# MORGAN AND MORECAMBE OFFSHORE WIND FARMS: TRANSMISSION ASSETS

Notification of Intention to Submit a Change Request Application

PINS Reference: EN020028  
Document reference: S\_MMCR\_1/F02

**Notification of the Applicants' intention to submit a request for changes to the Transmission Assets Application**

**Drawing Number:**  
BP-GBR-MORG-REG-0176

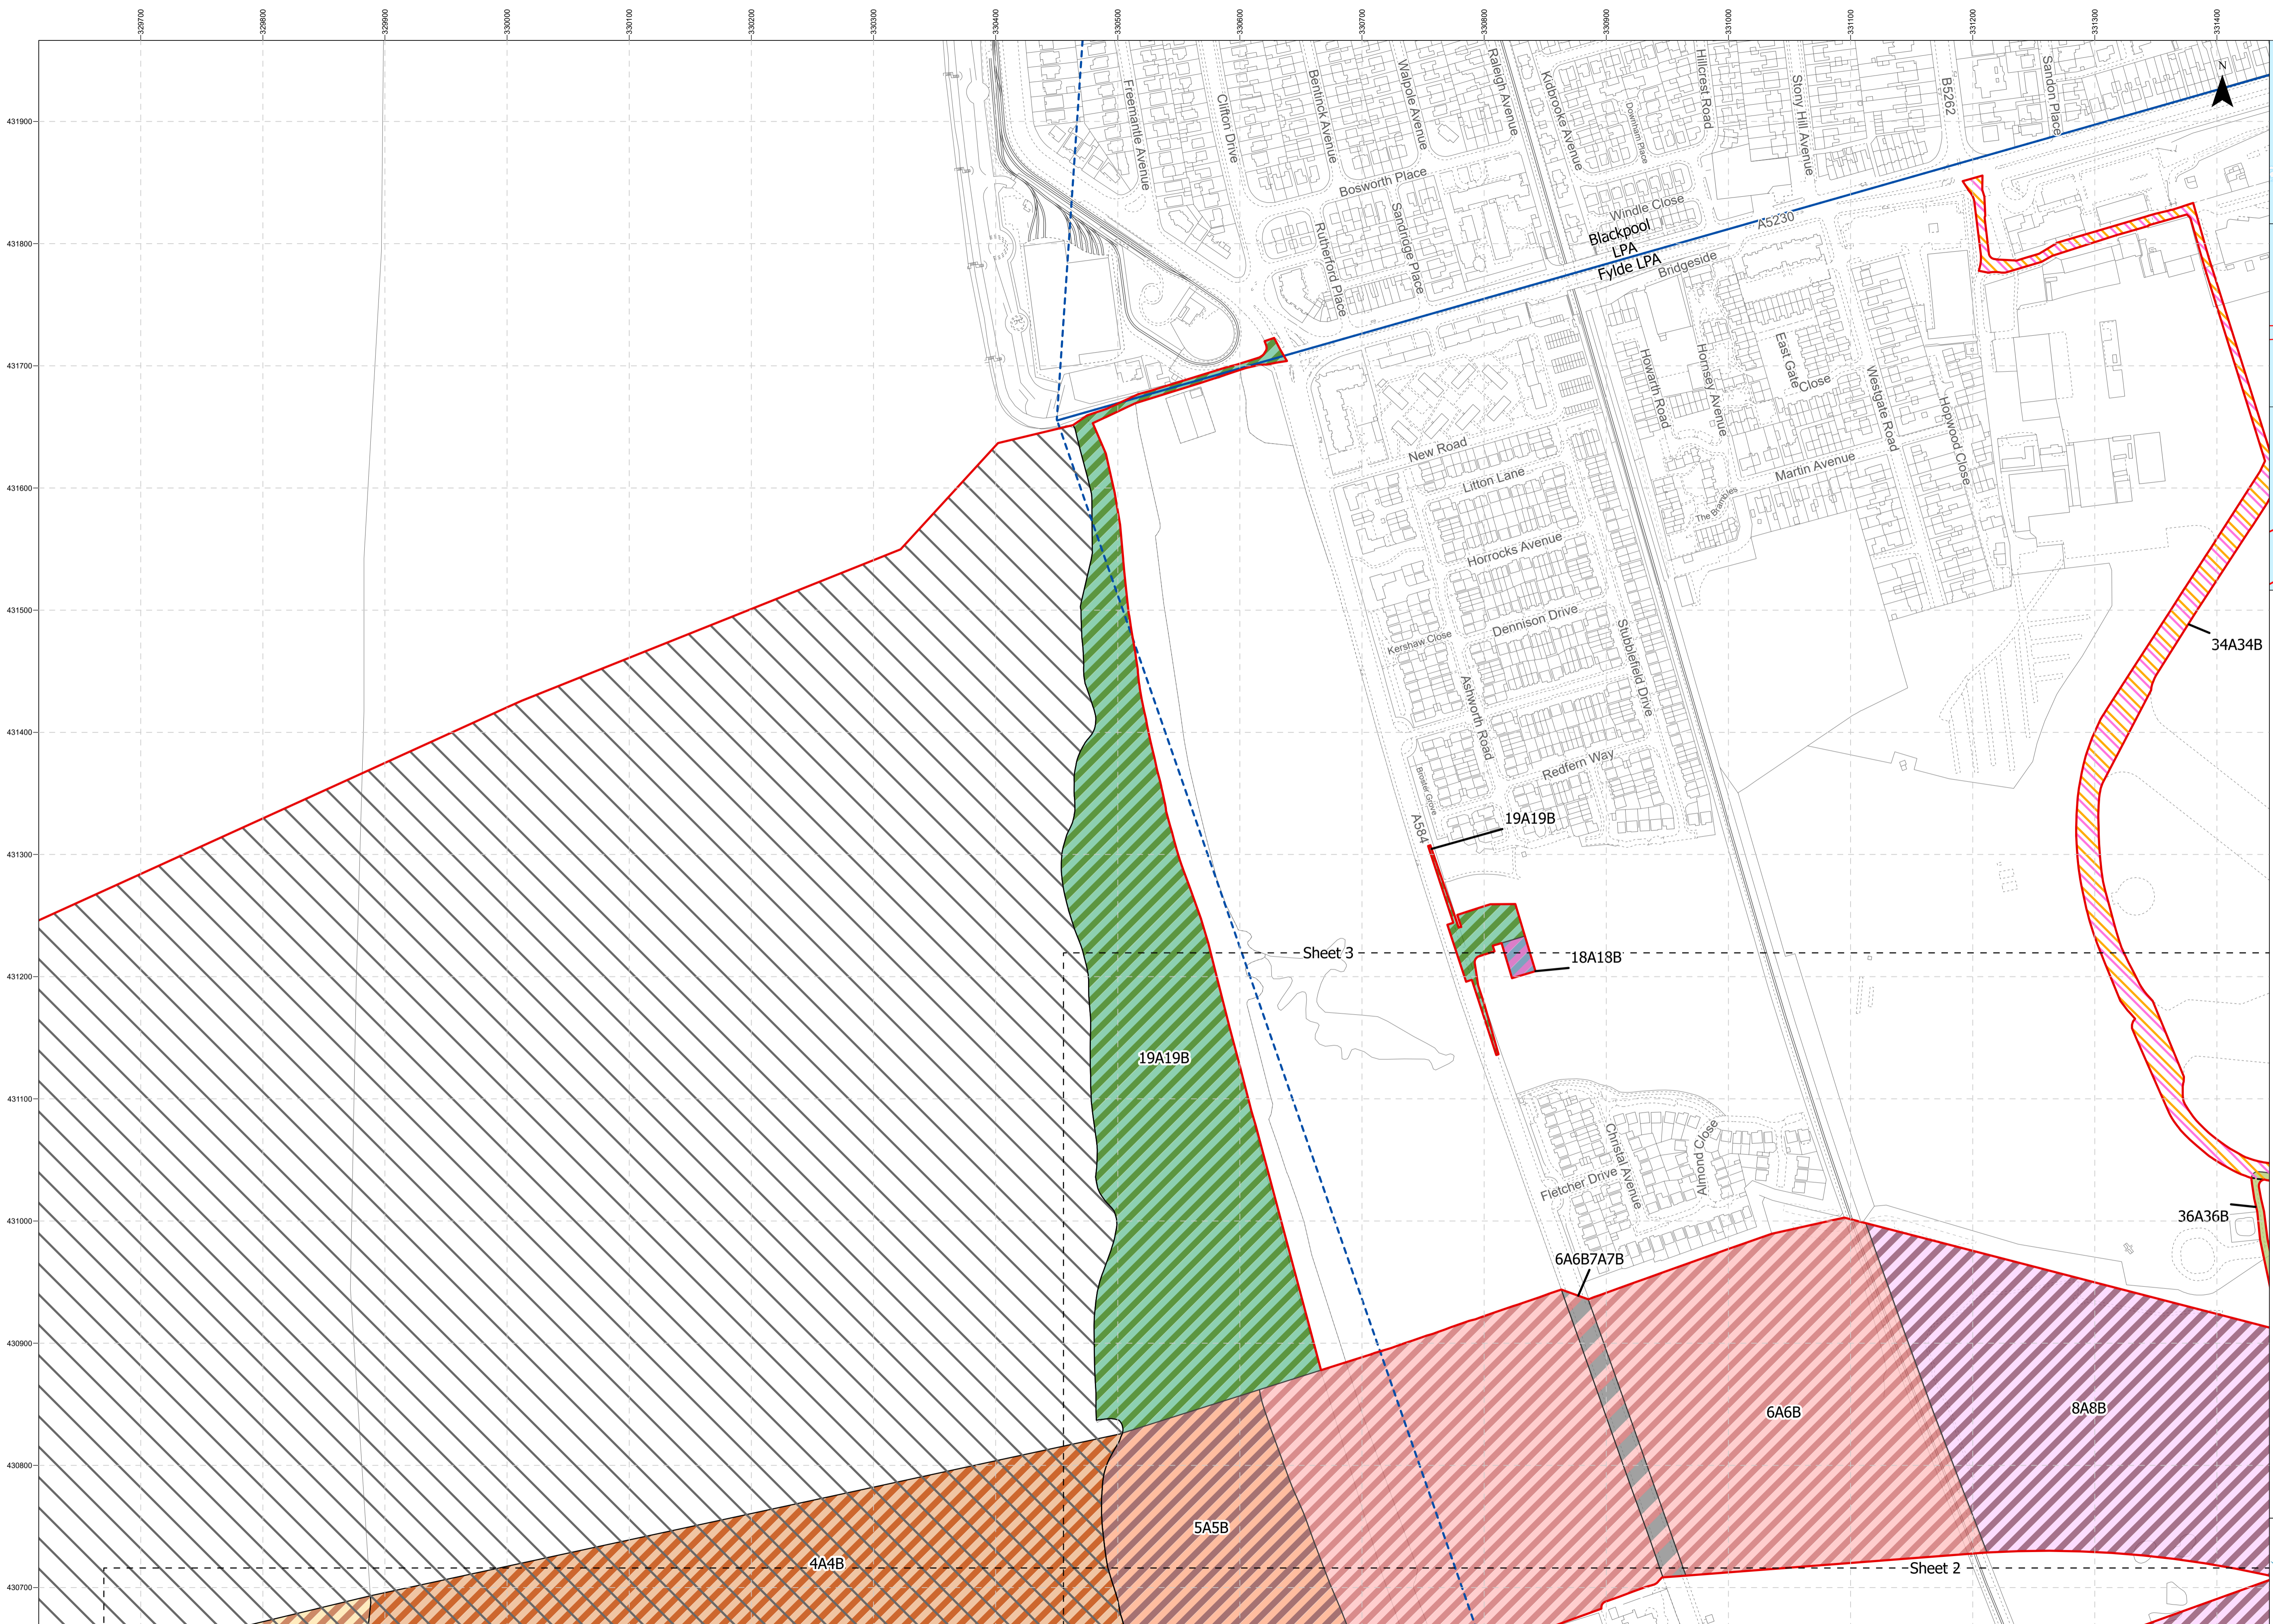
Change 3 involves amendment and reduction of the proposed Order Limits to remove an operational access (OAR\_MGMC\_3 identified on Sheet 1 of the Access to Works Plan (APP-157)) and its associated access route across Blackpool Airport operational land (Work Nos. 34A34B identified on Sheets 1, 3 and 4 of the Works Plans – Onshore and Intertidal – Part 1 of 2 (REP3-007)). Commitments made by the Applicants via the negotiations with Blackpool Airport have confirmed that operational access to the Transmission Assets (TJB) and onshore export cables will be taken via Access OAR\_MGMC\_5 from Leach Lane, as identified within Change 2. Access via OAR\_MGMC\_3 from Squires Gate Lane is no longer required. This involves the removal of four plots of land (plots 02-024, 02-025, 02-026, 02-027 and 02-028).

**Drawing Number:**  
BP-GBR-MORG-REG-0176

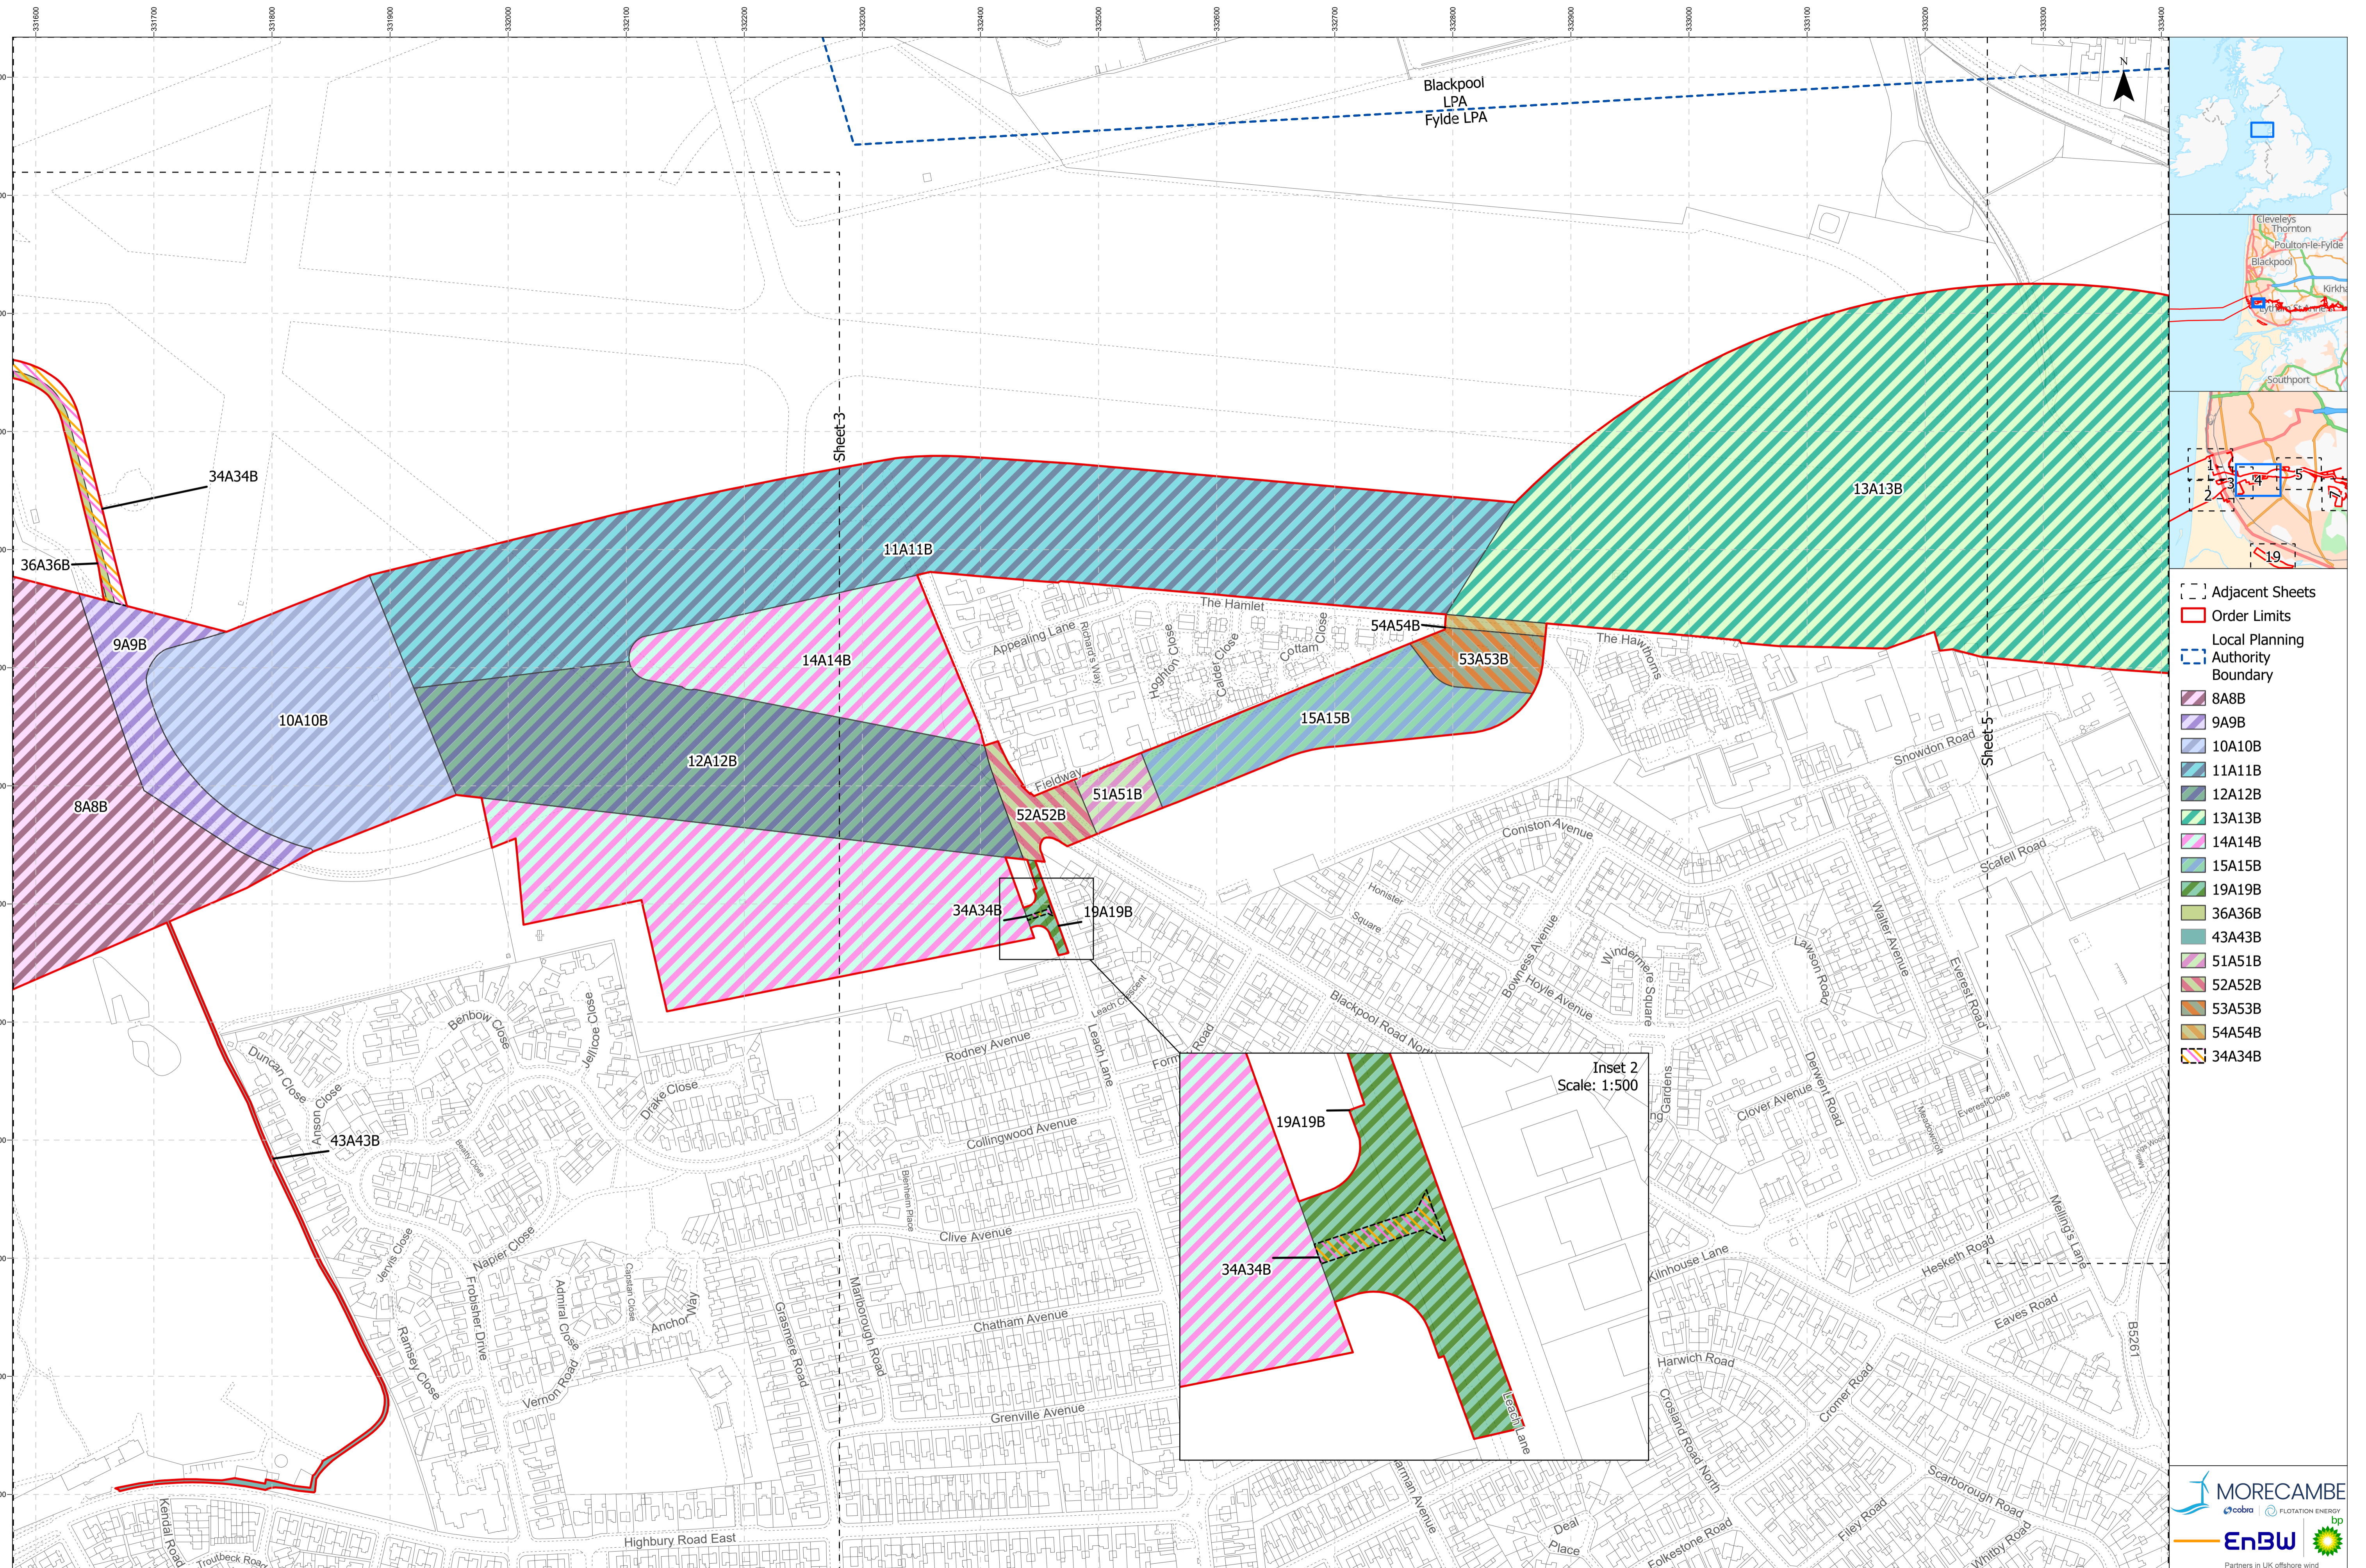
Change 2 involves amendment of the Access to Works Plan and Works Plans – Onshore and Intertidal (no amendment to the proposed Order Limits) to align the operational access to the Transmission Assets' Transition Joint Bays (TJBs) and onshore export cables via Access OAR\_MGMC\_5 from Leach Lane as identified on Sheet 4 of the Access to Works Plan (APP-157); and within Work Nos. 10A10B, 12A12B and 14A14B as identified on Sheet 3 and 4 of the Works Plans – Onshore and Intertidal – Part 1 of 2 (REP3-007). Commitments made by the Applicants through negotiations with Blackpool Airport have confirmed that operational access to the Transmission Assets' TJBs and onshore export cables will not be taken via Access OAR\_MGMC\_3 from Squires Gate Lane (see Change 3) therefore an alternative operational access is required. The use of Access OAR\_MGMC\_5 from Leach Lane has been discussed and agreed with

Change 4a involves amendment and reduction of the proposed Order Limits to remove any potential interaction with Runway 10/28 and land north of Runway 10/28 within Blackpool Airport operational land; currently included within Work Nos. 13A13B on Sheets 4 and 5 of the Works Plans – Onshore and Intertidal – Part 1 of 2 (REP3-007). The Applicants have made a commitment through negotiations with Blackpool Airport that cables will not be installed beneath Runway 10/28 and that the runway and land to the north of the runway is considered a restricted area, which means that no installation activities will take place. Therefore, this will result in a reduction of the Order Limits within Blackpool Airport. This involves the reduction in one plot of land (plot 04-024).

Change 4b involves amendment and reduction of the proposed Order Limits to reduce interaction with Blackpool Road Recreation Ground and reduce the interaction with one of the St Anne's Football Club 11-a-side pitches; currently included within Work Nos. 15A15B, 53A53B and 54A54B on Sheets 4 and 5 of the Works Plans – Onshore and Intertidal – Part 1 of 2 (REP3-007). Following feedback received from Fylde Borough Council and St Annes FC, and due to the commitments made by the Applicants through negotiations with Blackpool Airport not to undertake construction activities in the restricted area (as explained under Change 4a above), the swept path of onshore export cables in the northern section of Blackpool Road Recreation Ground can be reduced. This involves the reduction in five plots of land (plots 04-015, 04-016, 04-017, 04-018 and 04-019). [As requested during Issue Specific Hearing 2 on 29 July 2025, the Applicants will provide a figure within the Change Request application which illustrates the change overlaid with the current layout of 11-a-side football pitches at the Blackpool Road Recreation Ground \(which the Applicants acknowledge may be subject to future reconfiguration depending on the needs of the users\).](#)
